From: Simon Davis
Sent: 07 February 2019 14:40
To: 'Charlie Brown' [REDACTED]
Cc: David Keene [REDACTED]
Subject: RE: Planning Consultation on: BE/137/18/PL

APPLICATION **BE/137/18/PL**

Site Address: Rolls Royce Motor Cars Technology and Logistics Centre
Newlands Road Bersted

Description of Works: Temporary storage building & associated works

Proposed Site Layout Plan

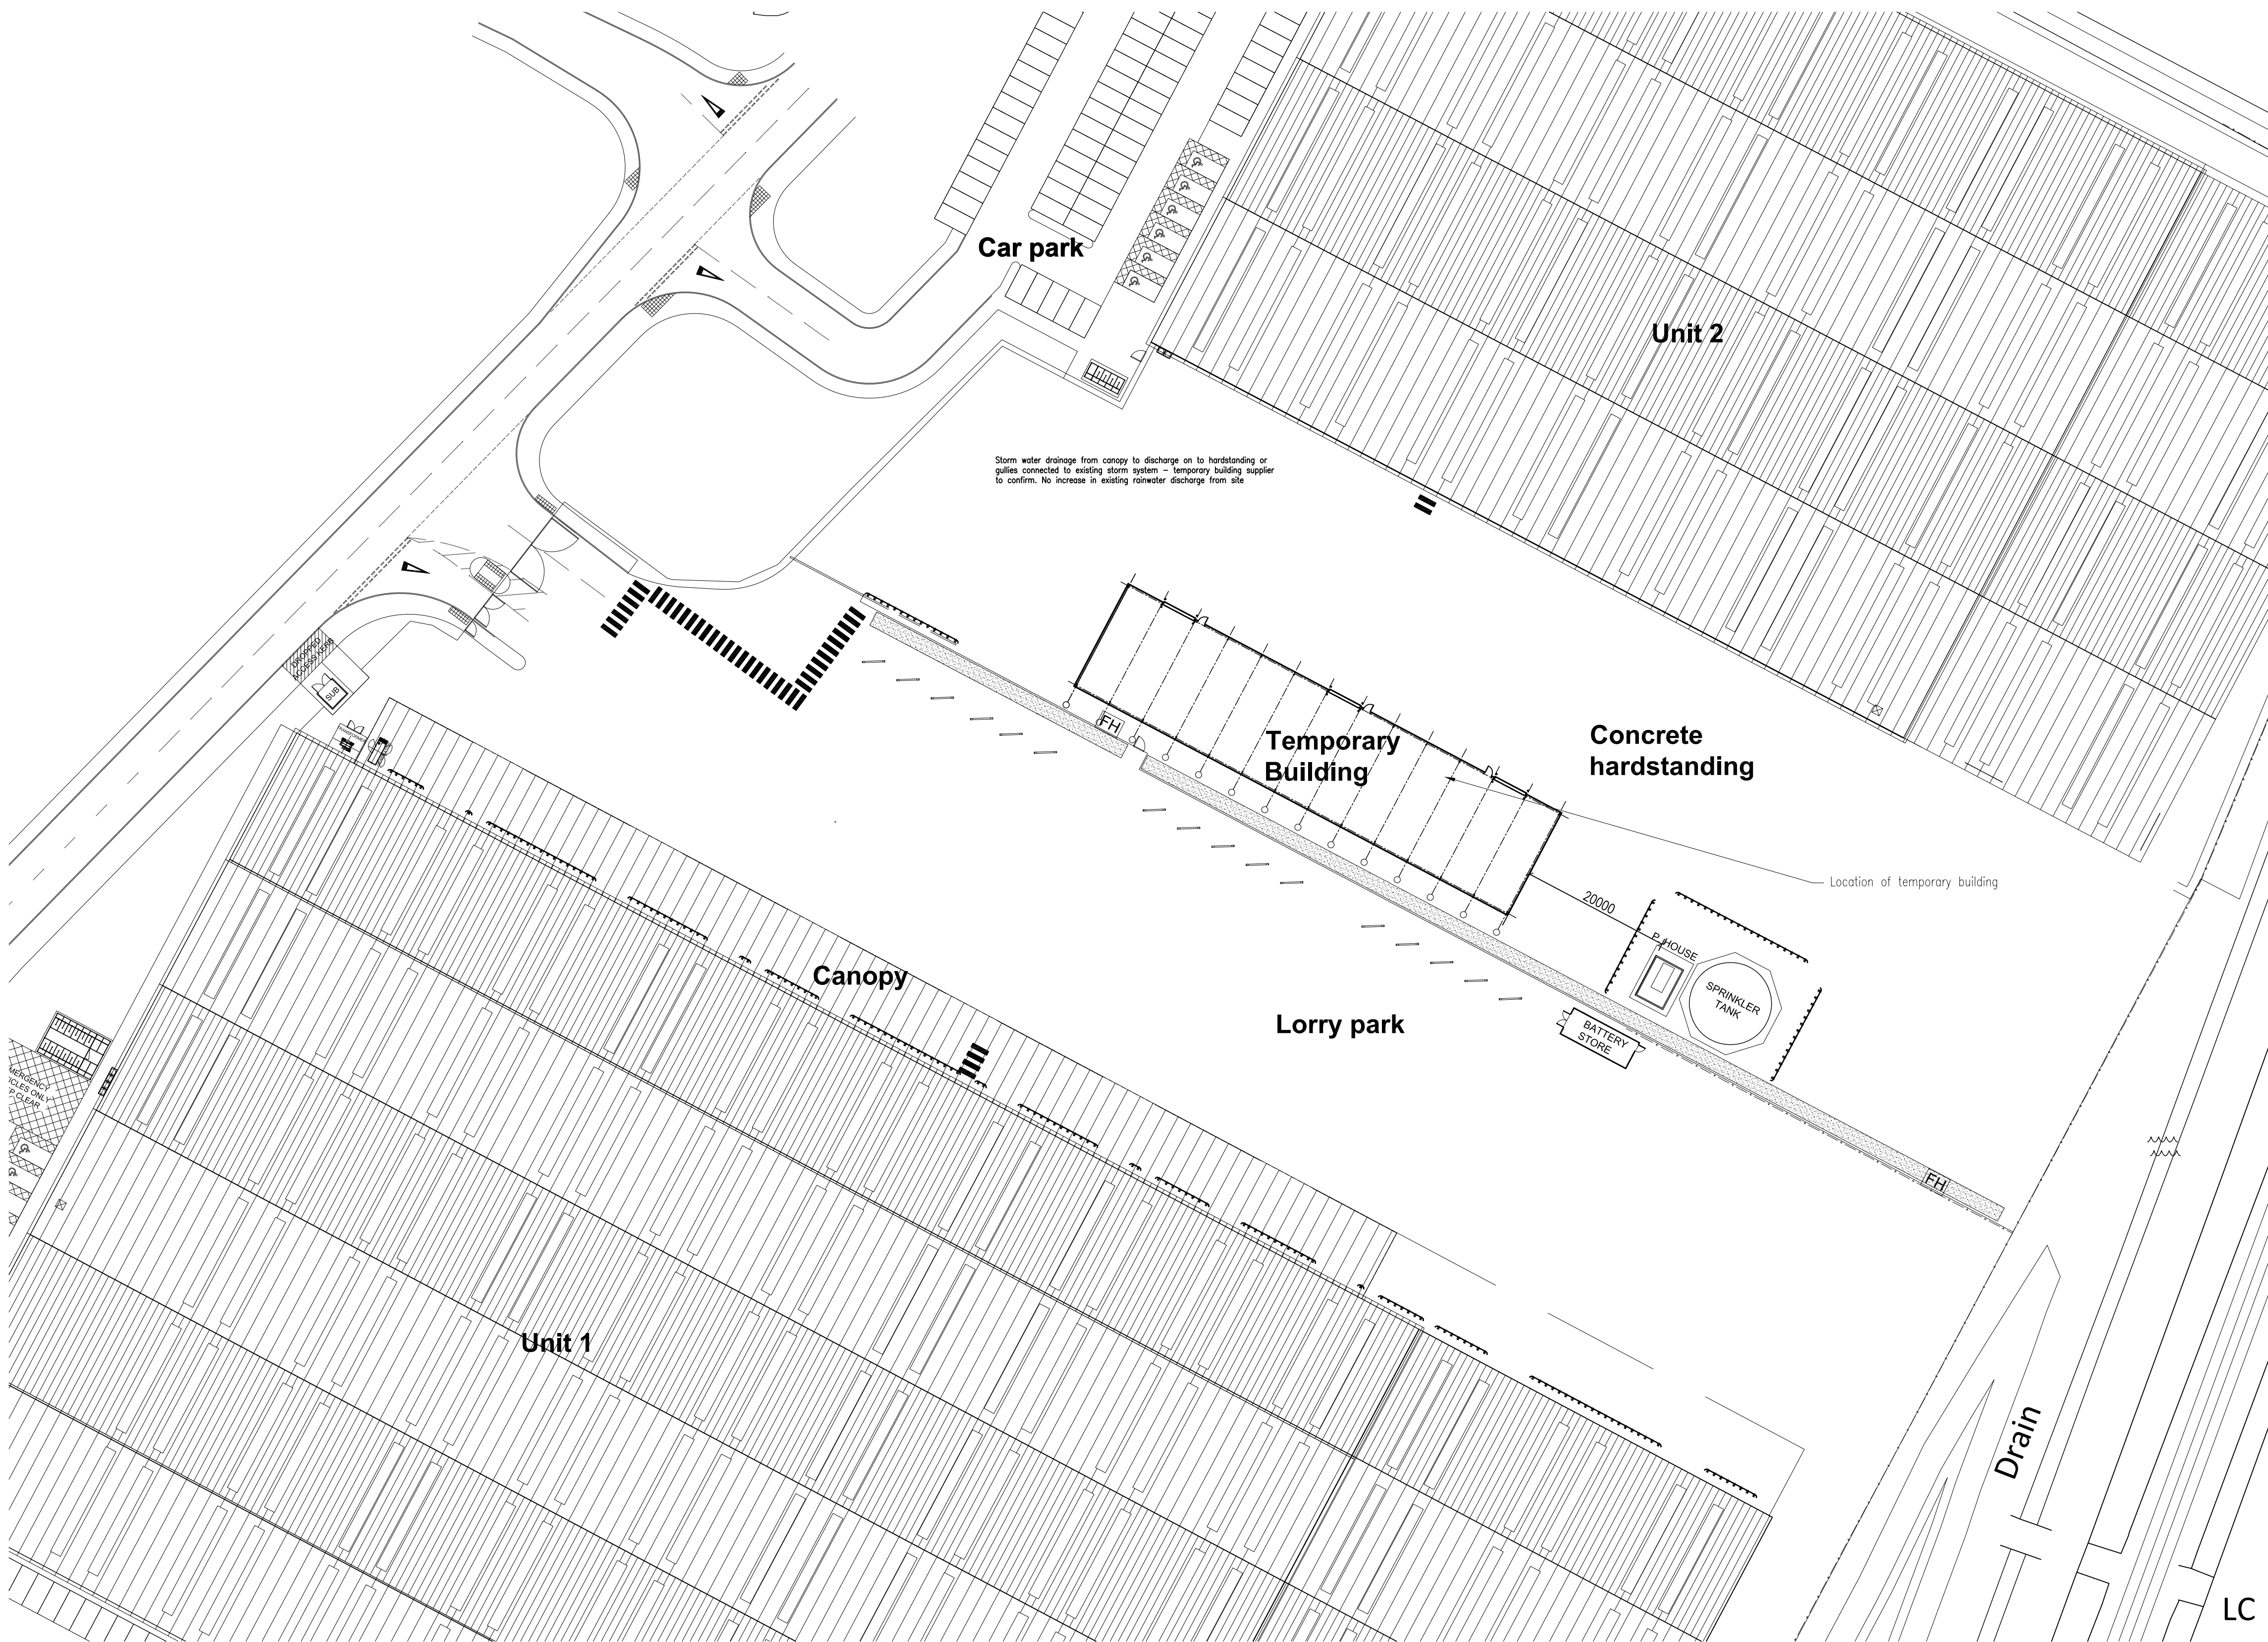
We require confirmation that the proposed temporary structure will not be located directly on top of the existing surface water drainage network. Please can the applicant provide as built survey of the surface water drainage network.
